## DRB CASE ACTION LOG

DRB Application No.: 04DRB-00822 Project # 1002821  
 Project Name: NORTH ALBUQUERQUE ACRES, TALEA COURT  
 Agent: ADIL BIZVI-315-6484 Phone No.: 298-3477 (W), 315-6484 (cell)

**CITY OF ALBUQUERQUE  
PLANNING DEPARTMENT  
Development Review Board  
June 2, 2004  
Comments**

**RE: N.A.A. Talea Court/final plat**

INDEXING INFORMATION FOR COUNTY CLERK OWNER: HADARI/RIZVI LOCATION: SECTION 21, T. 11 N., R. 4 E., N.M.P.M. SUBDIVISION: TALEA COURT	DRAWN: E W K	SCALE: 1" = 40'	FILE NO. SP-1-02-04
	CHECKED: T D J	DATE: 16 FEB 2004	SHEET 2 OF 2
	DRAWING NO. SP10204.DWG

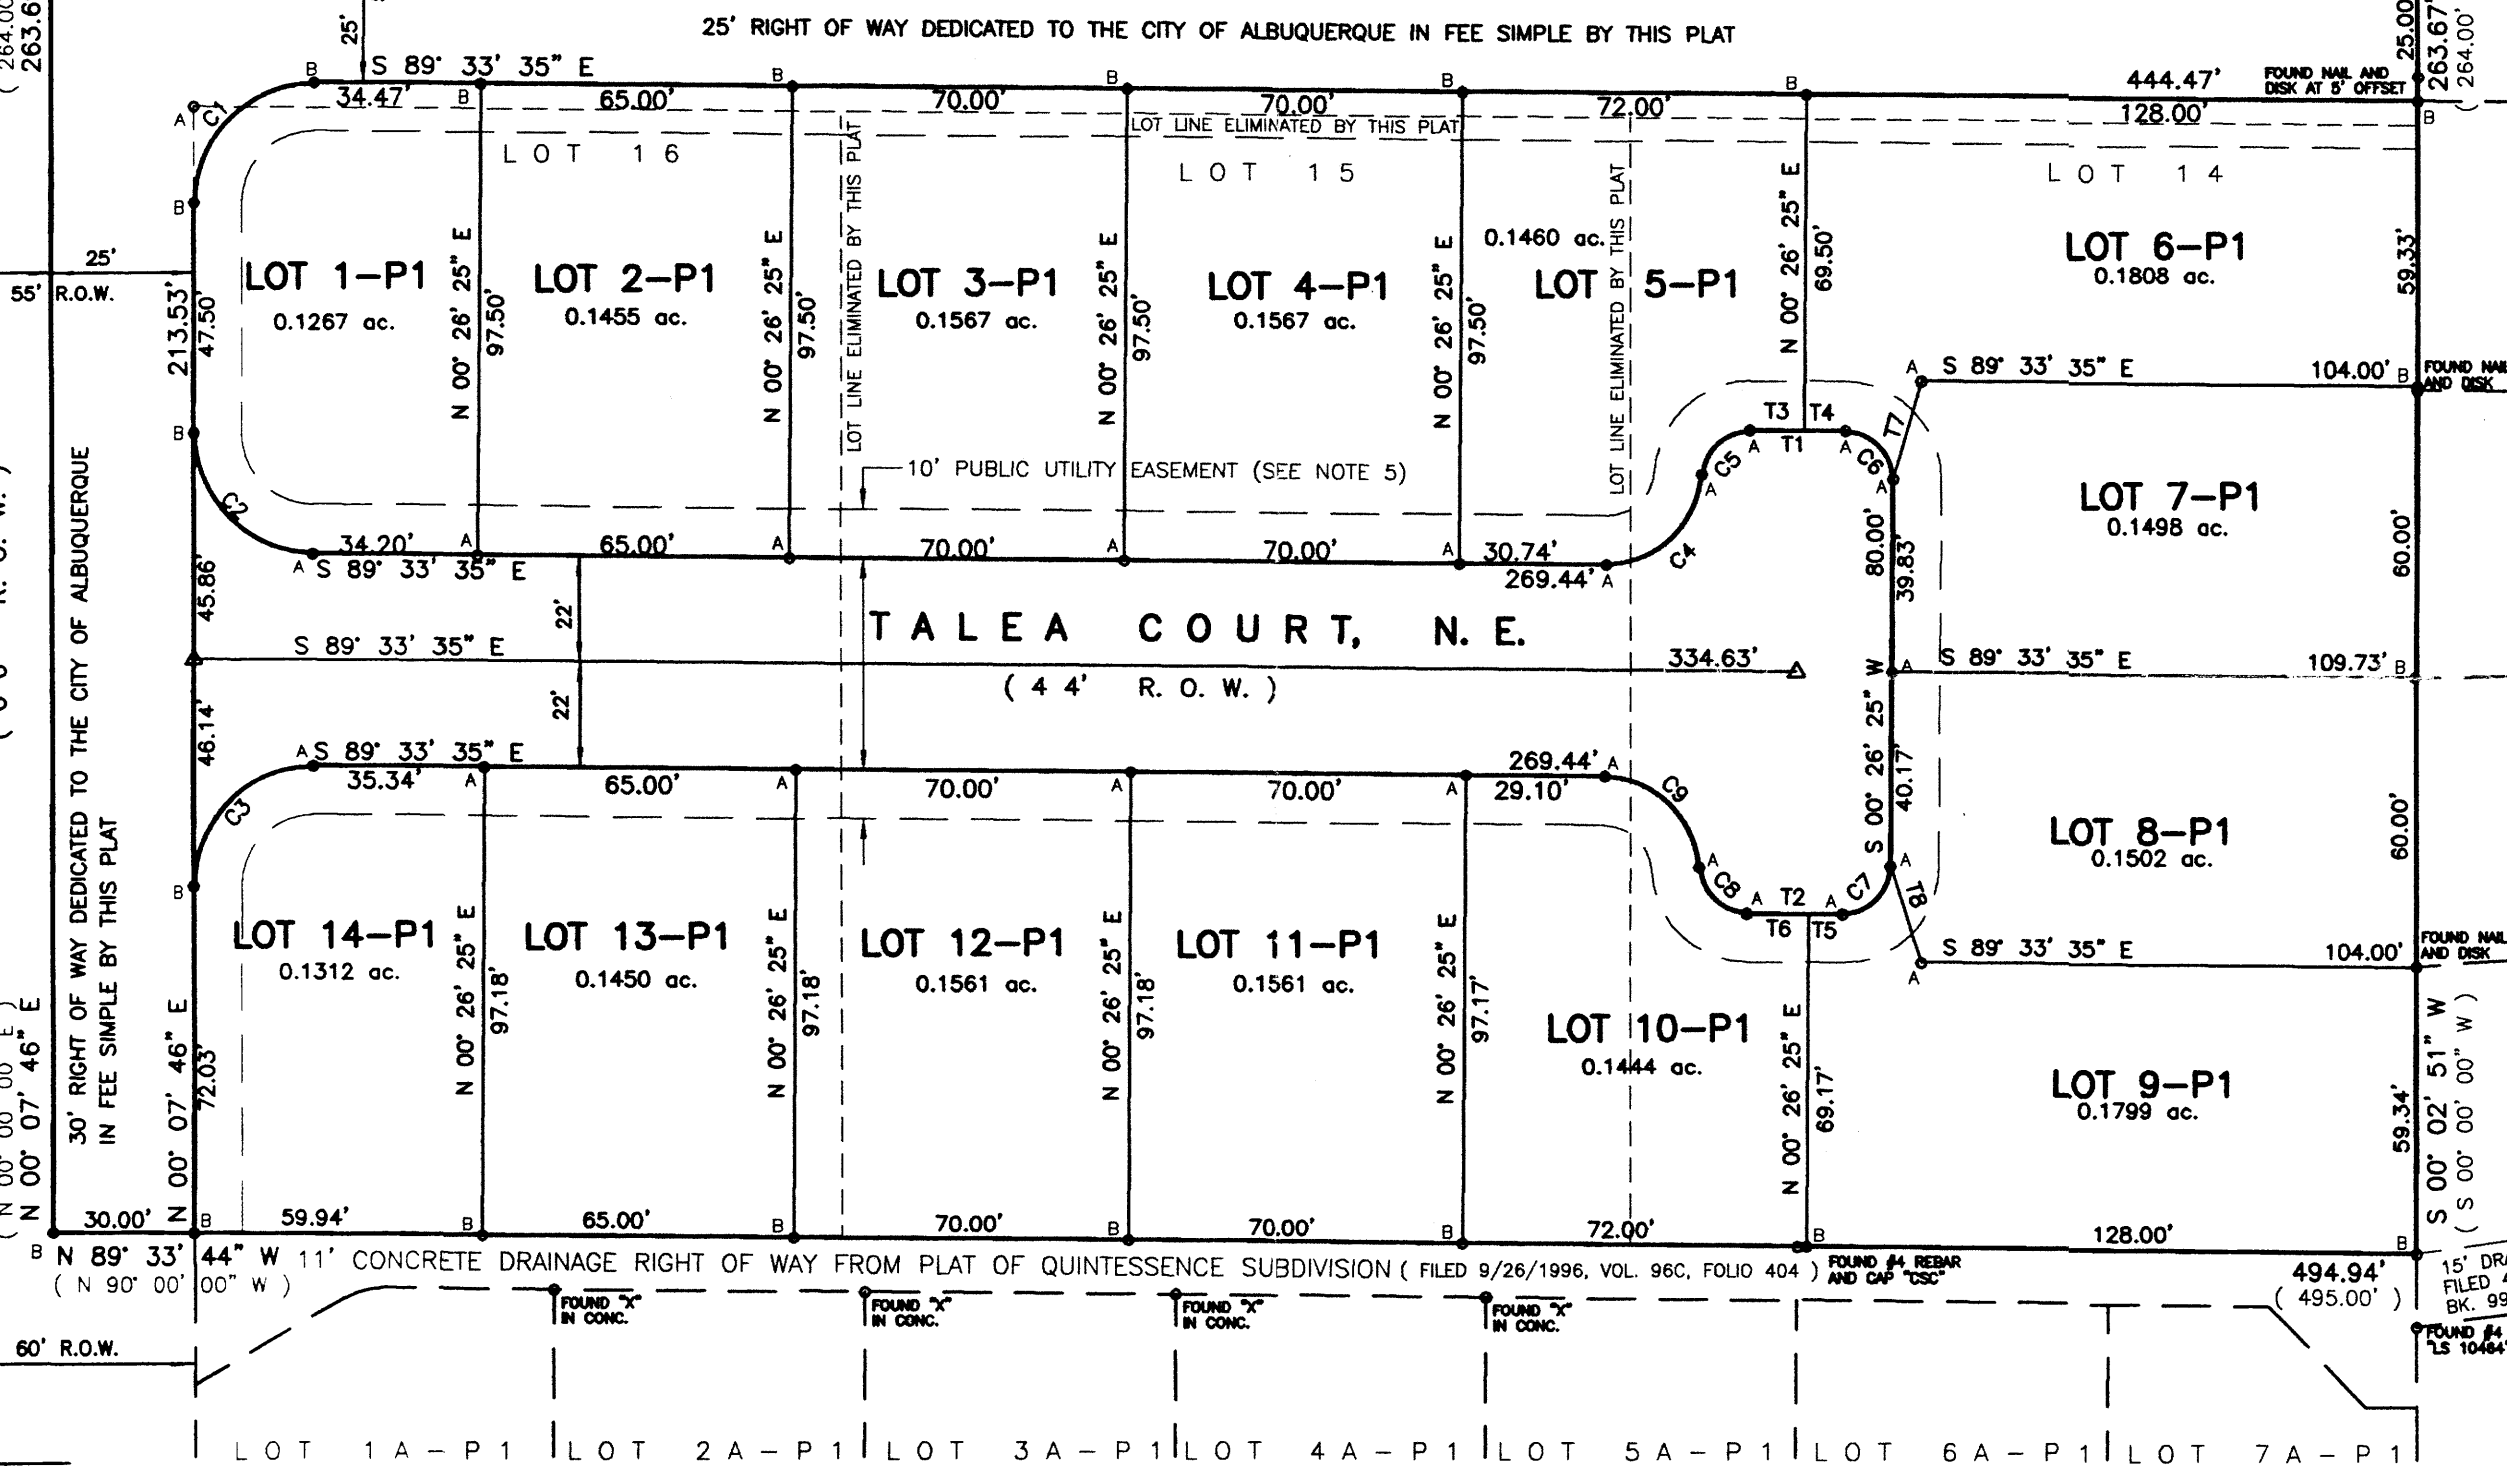
Add one of the following notes to the plat to fulfil the detached open space requirement associated with the RD zoning.

All open space requirements are met on the lot with the dwelling per the provisions of Section 14-16-3-8 (A) (1).

Total remaining open space requirements are met via a cash payment to the City of Albuquerque per the provisions of Section 14-16-3-8 (A) (2).
